December 15, 2022

Re: Wall Removal Letter  
93 Marian Lane  
Spring Lake, NC

At your request, a limited structural evaluation for removing wall sections in the home located at the subject address was performed on December 12, 2022. The evaluation was performed by Tyler Royster, EI of Giles Flythe Engineers. It is our understanding that you plan to remove the following sections of wall:

WALL REMOVAL LOCATION SKETCH

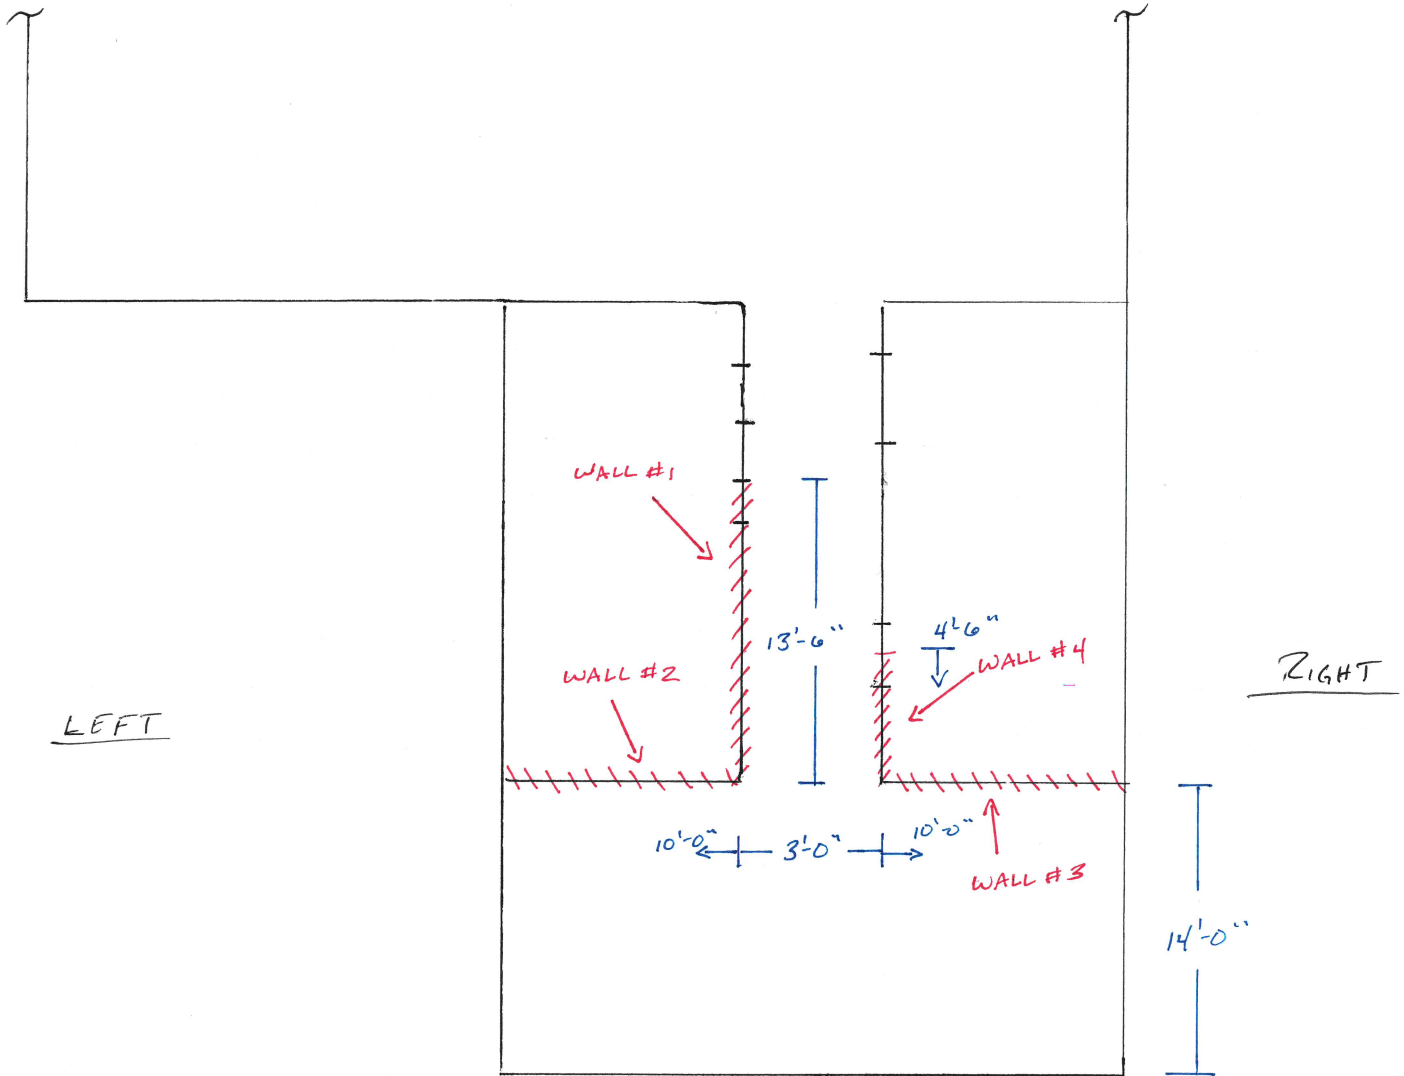
- We recommend installing a 2-1.75"14" LVL beam spanning a maximum of 19'-0" between the load-bearing points. The new beam should be supported by 3-2x4 jack studs at each of the load-bearing points.

- To install the new LVL beam as a flush beam, temporary walls should be installed directly beneath both sides of the existing ceiling joists (not greater than 18" from the existing Wall #4) and the ceiling joists should be cut back to allow the installation of the new member with the bottom of the new LVL beam installed flush with the bottom of the existing ceiling joists. The existing ceiling joists should be attached to the new LVL beam with new Simpson LUS26 hangers (or equivalent). New CS16 straps that extend a minimum of 1'-4" in each direction should be installed along the bottom edge of the discontinuous ceiling joists.

- A new 16x16 grouted CMU block pier should be installed below the jack studs at the rear bearing point. The new pier is to be supported by a new 30"x30"x10"-thick concrete footing at the rear bearing location. Note, 2x blocking is to be installed between the jack studs and masonry piers within the floor cavities. Note, the contractor shall verify the presence of a minimum 12" wide continuous concrete footing below the front foundation wall. If the concrete footing is not present or inadequate, we recommend installing a new 24"x24"x10"-thick concrete footing below existing foundation wall at the front bearing location.
